# PLAN 2 The Holly - LH 'ENGLISH COUNTRY' ELEVATION

Lot 2B Heritage @ Neill's Creek  
1701 Neills Creek Road  
Lillington, NC 27546

PLAN 2 - THE HOLLY - RH  
Cover Sheet 'English Country'

Foundation Slab Options 'English Country'

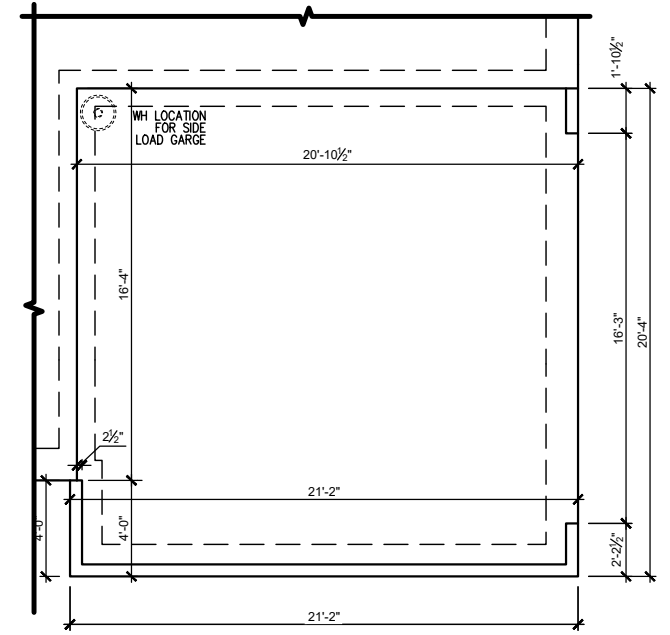
Reduce this off set from 3'-6" to 2'-0"

THE HOLLY - RH
 First Floor Plan Options 'English Country'

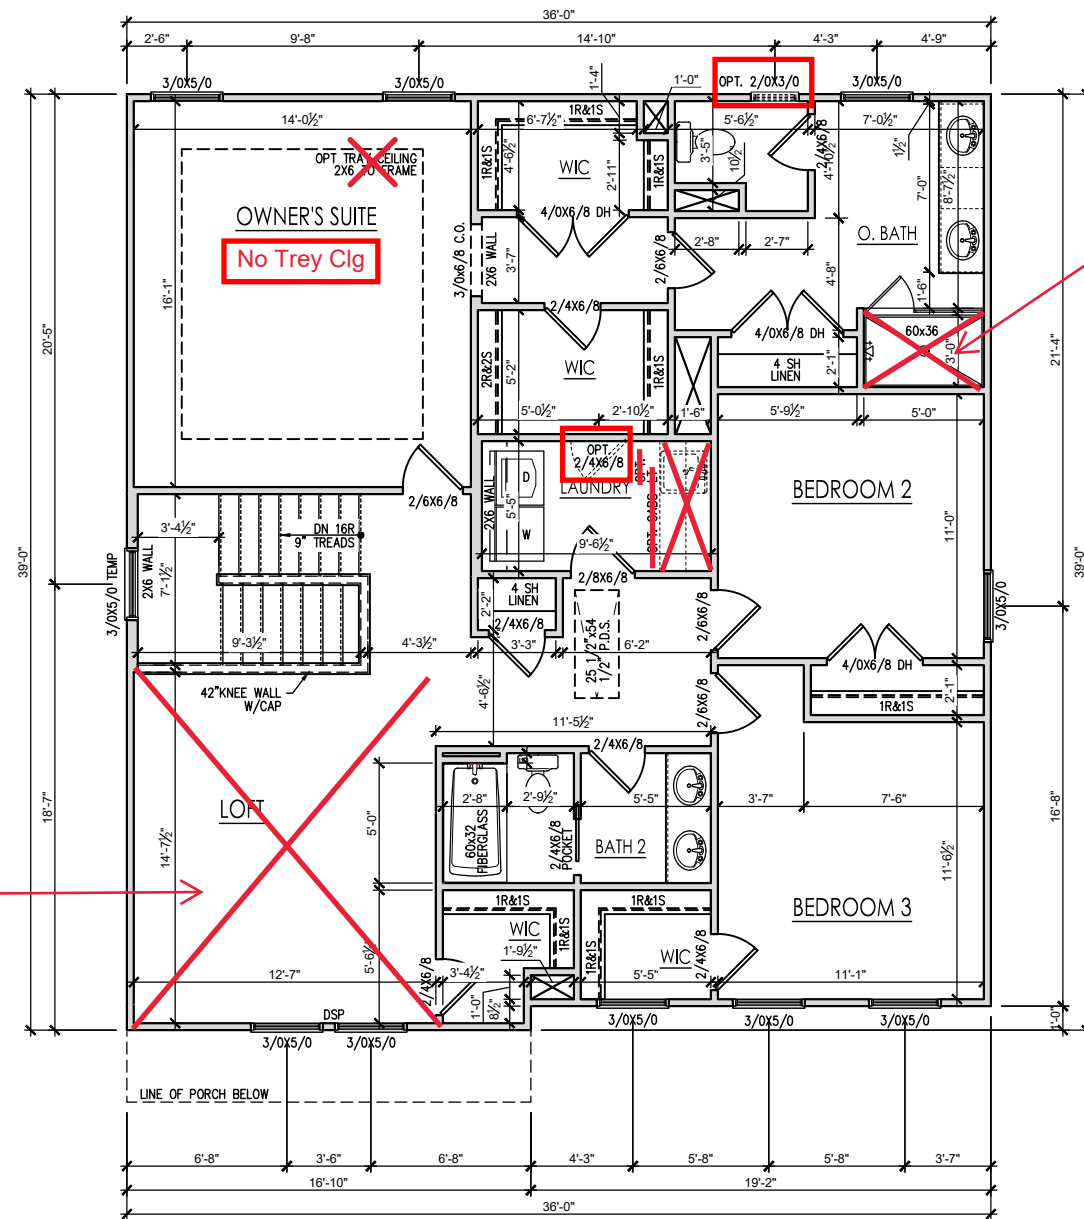
Make this Smart Door Delivery a LH door and swing 'in'

Reduce this offset from 3'-6" to 2'-0"
